Charlotte-Mecklenburg Planning Department

SUBJECT: Administrative Approval for Petition No. 2008-031 Mountain Island Promenade, LLC

Attached is the revised site plan for the petition above. This request allows the modification of the proposed site plan as listed below. Since these changes do not alter the intent of the development and meets the requirements of the Charlotte Zoning Ordinance Section 6.207 Alterations to Approval, minor changes, I am administratively approving this plan. Please use these plans when evaluating requests for building permits and certificates of occupancy.

**CO.0**

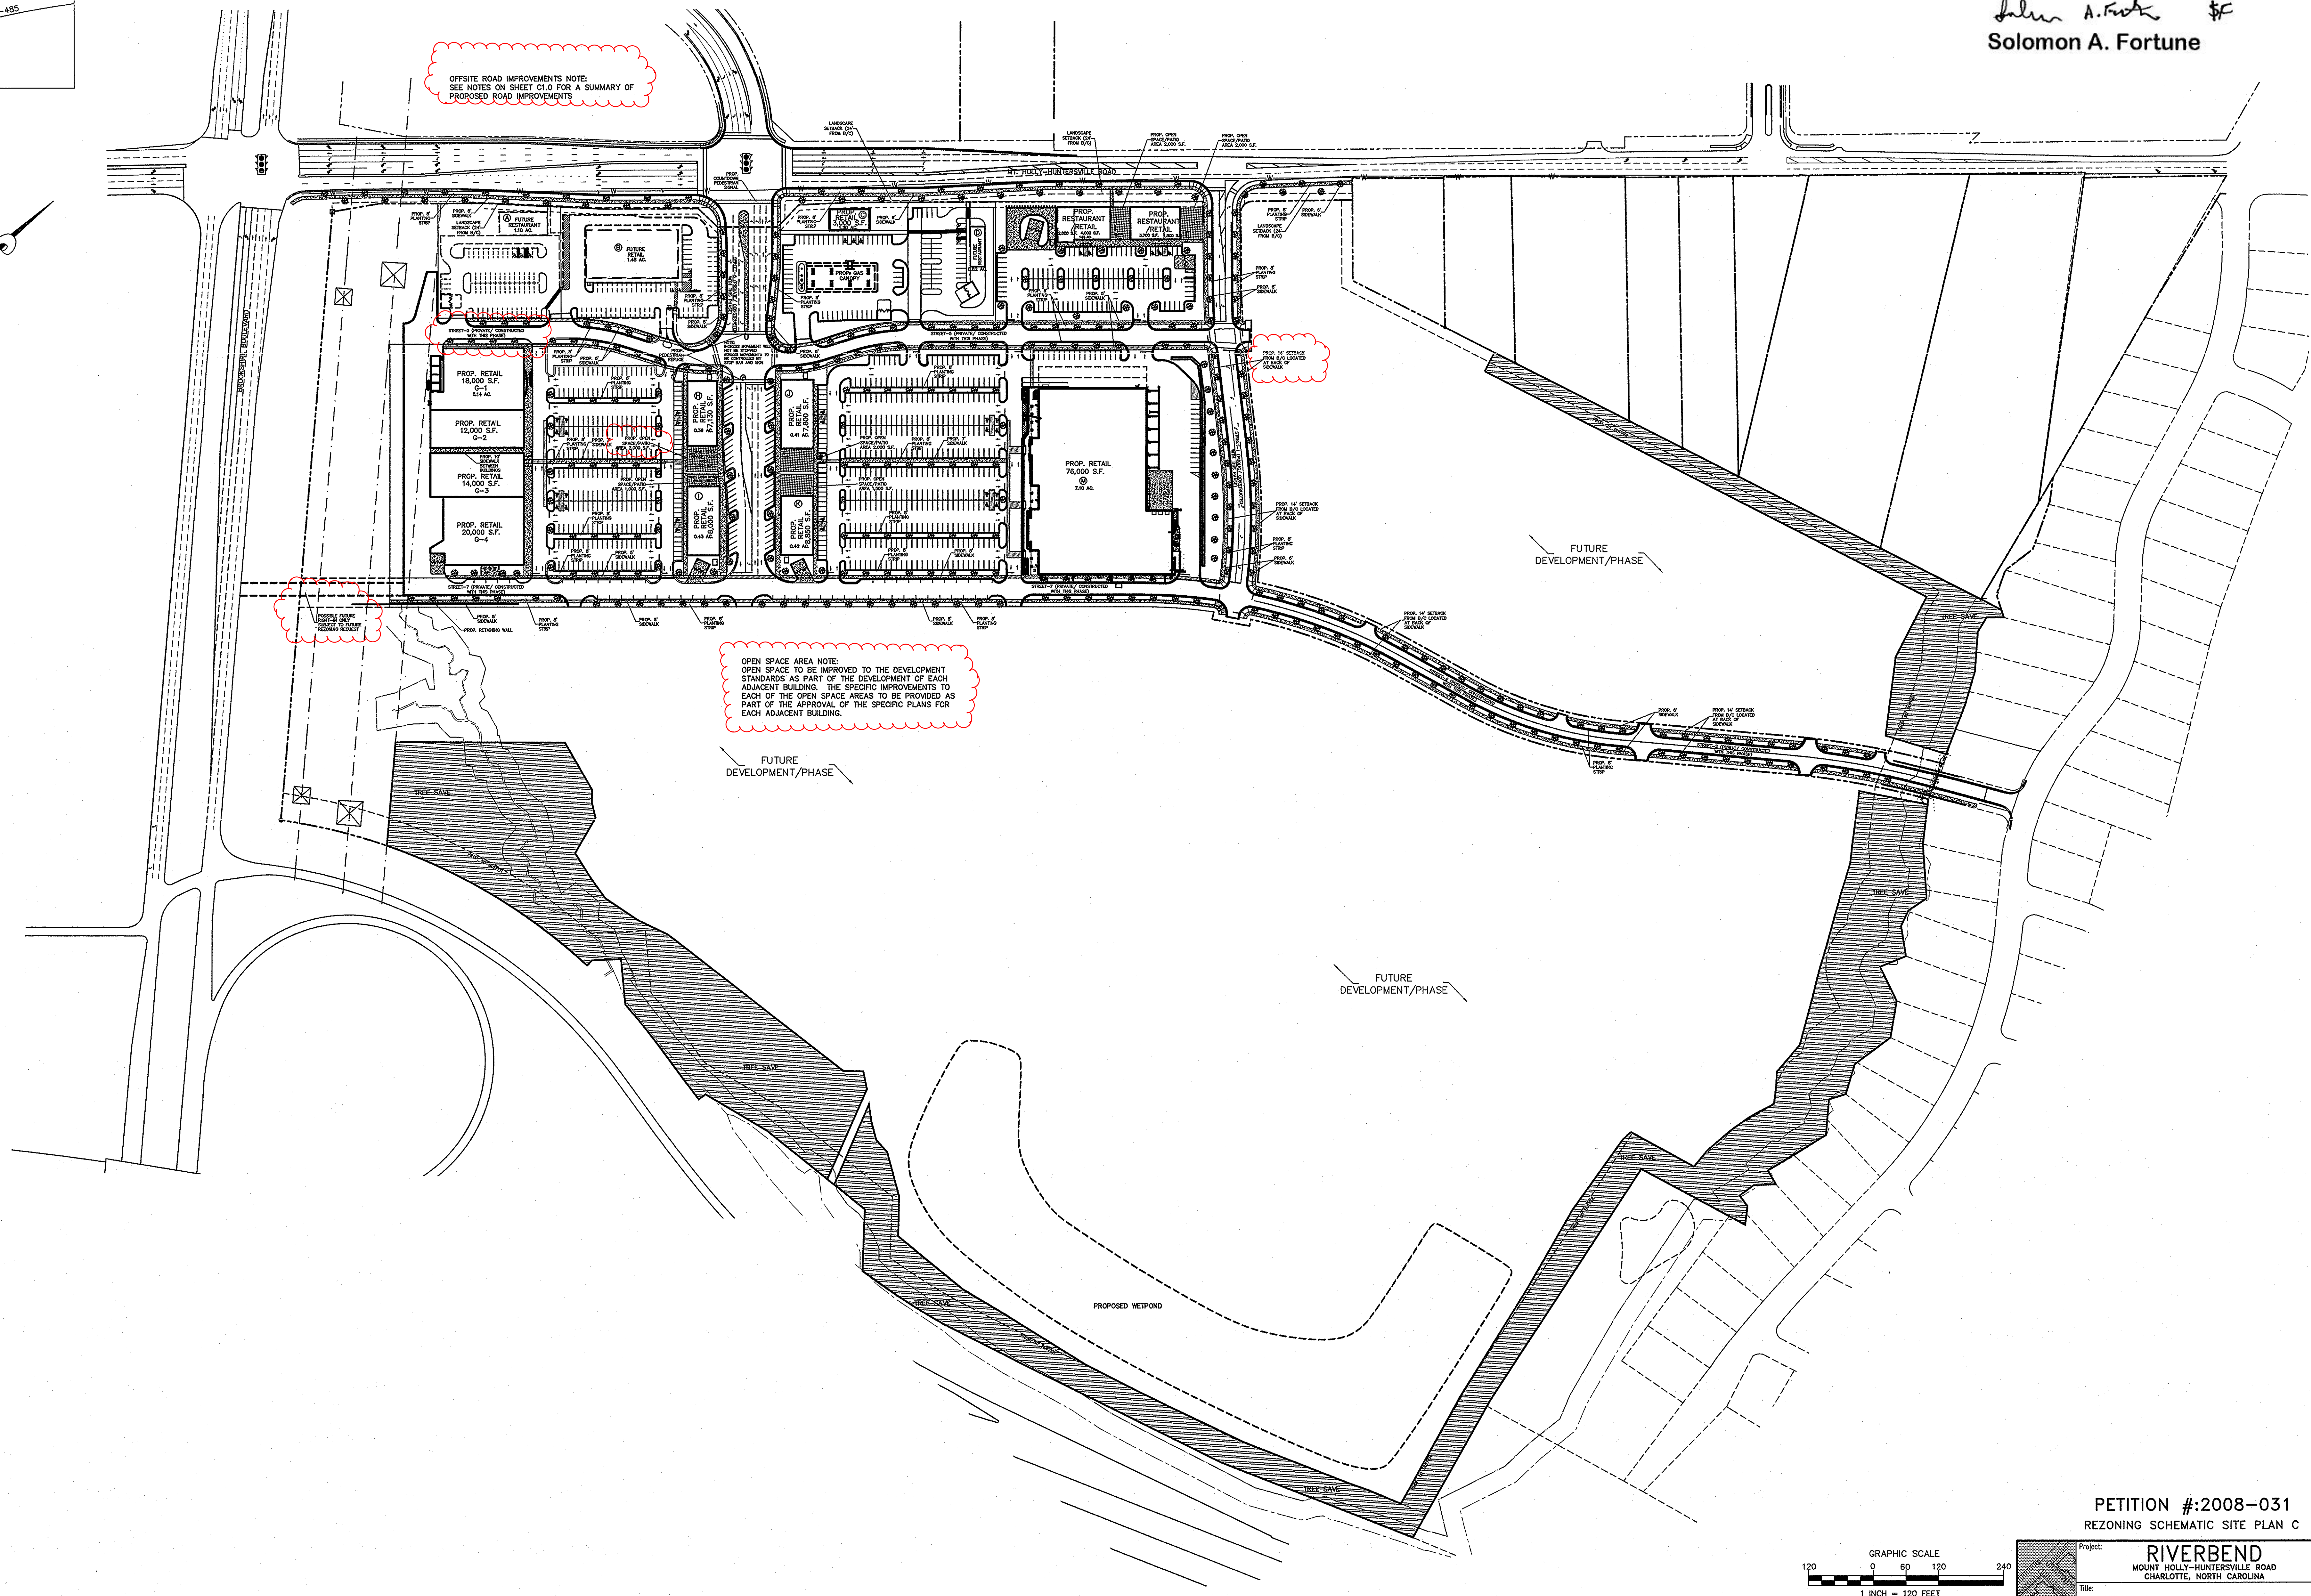
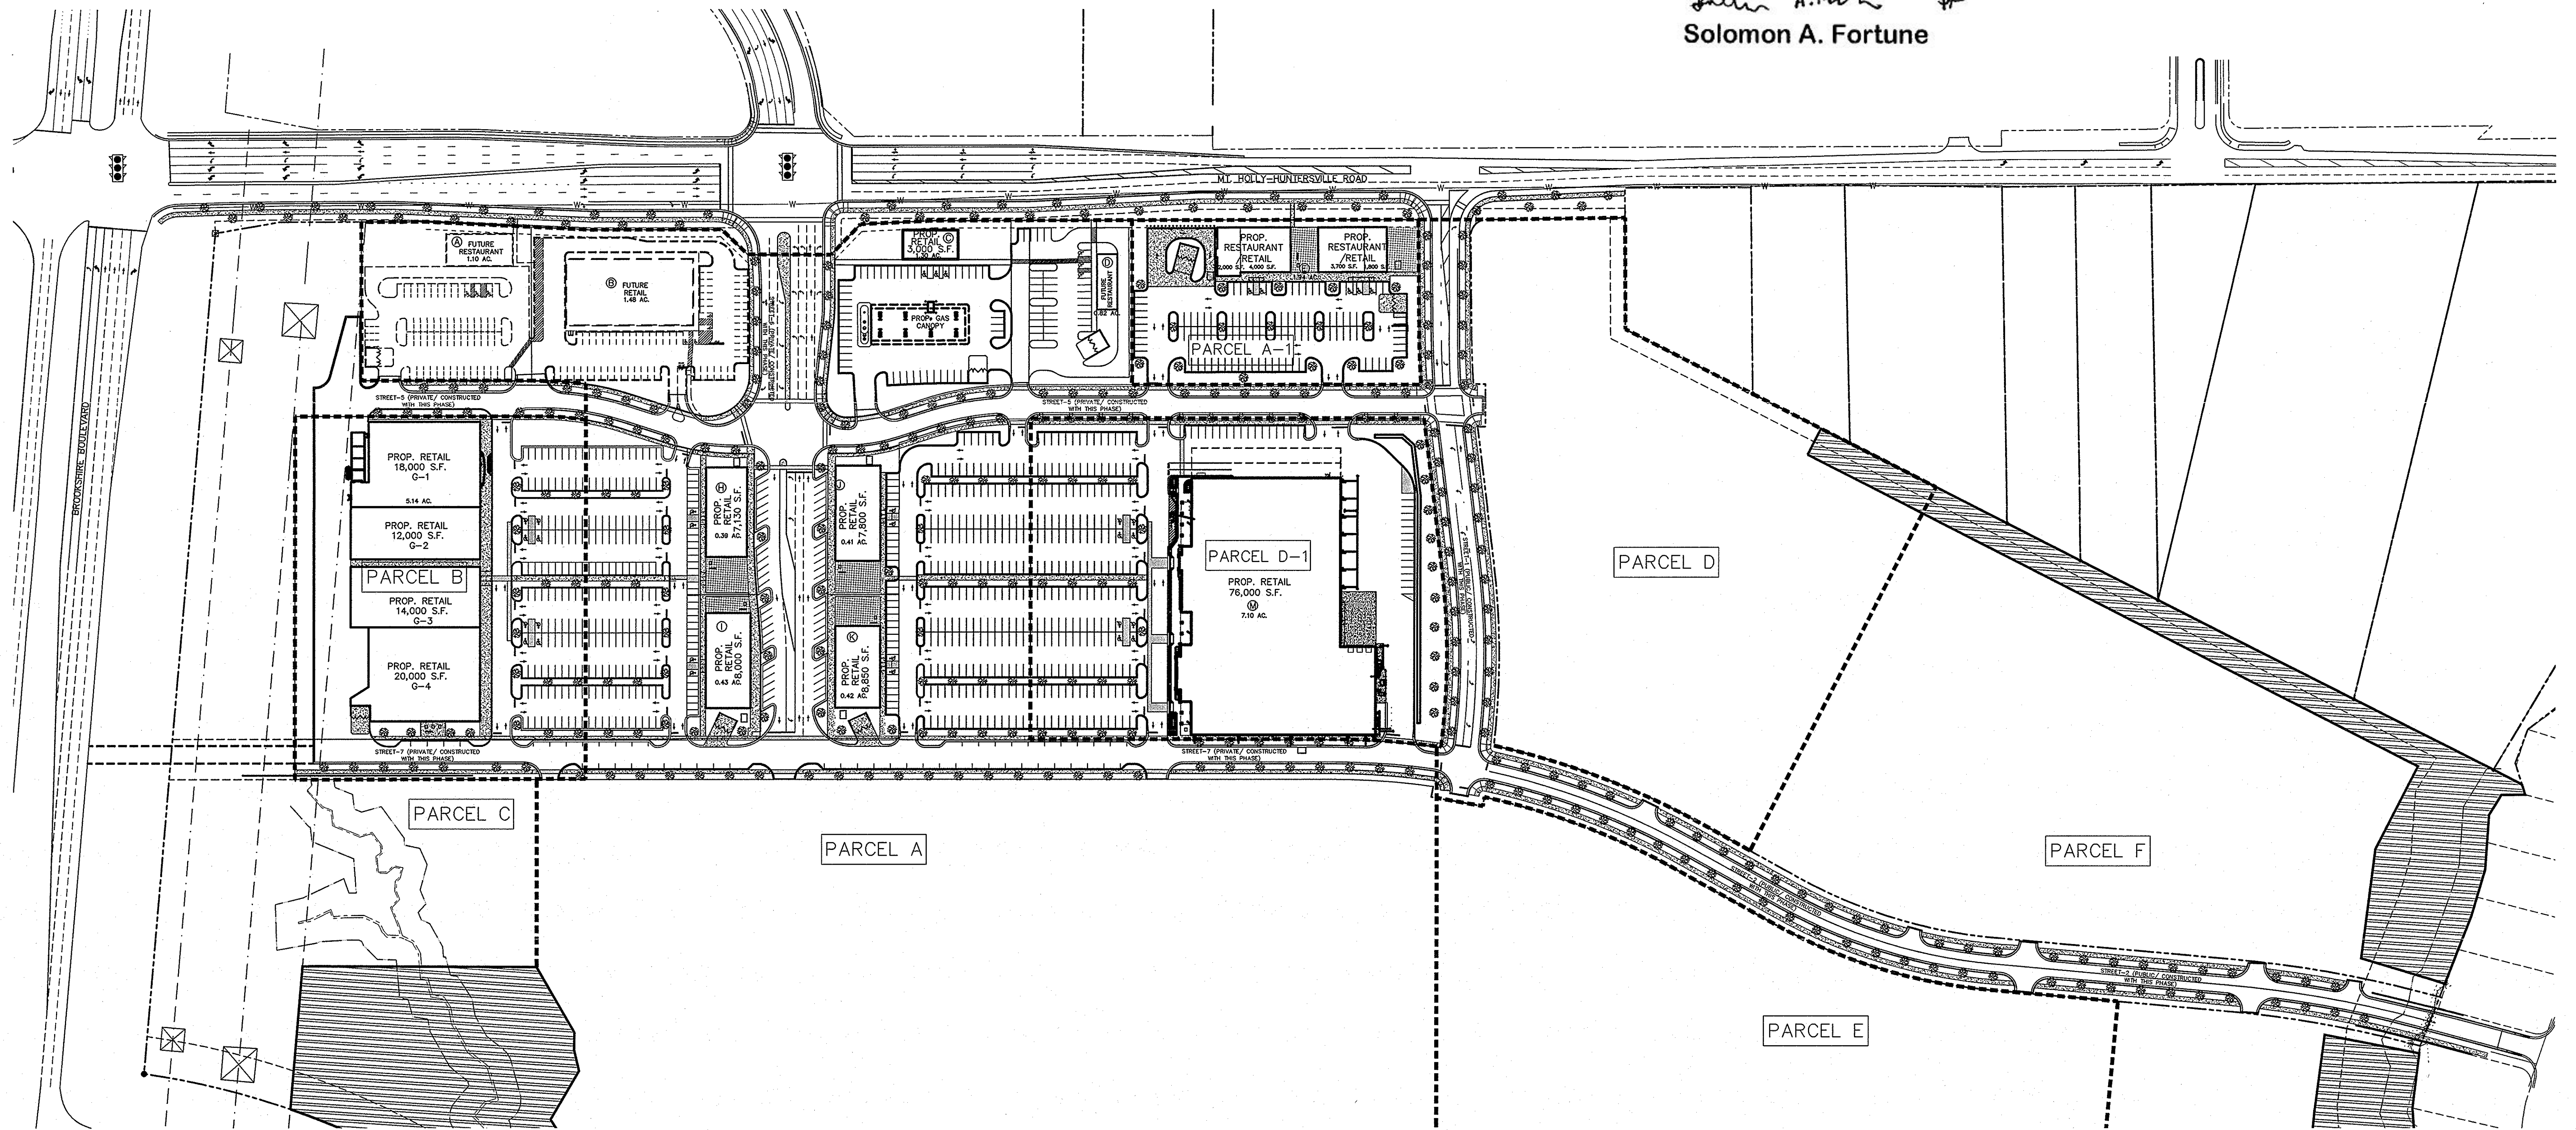
- General layout for proposed retail buildings.
- Note modification: Elevation and review will happen prior to commercial building standards review.
- Master site development record
- Open space and green areas are tied to certain buildings being developed.
- Screening wall along proposed internal public street
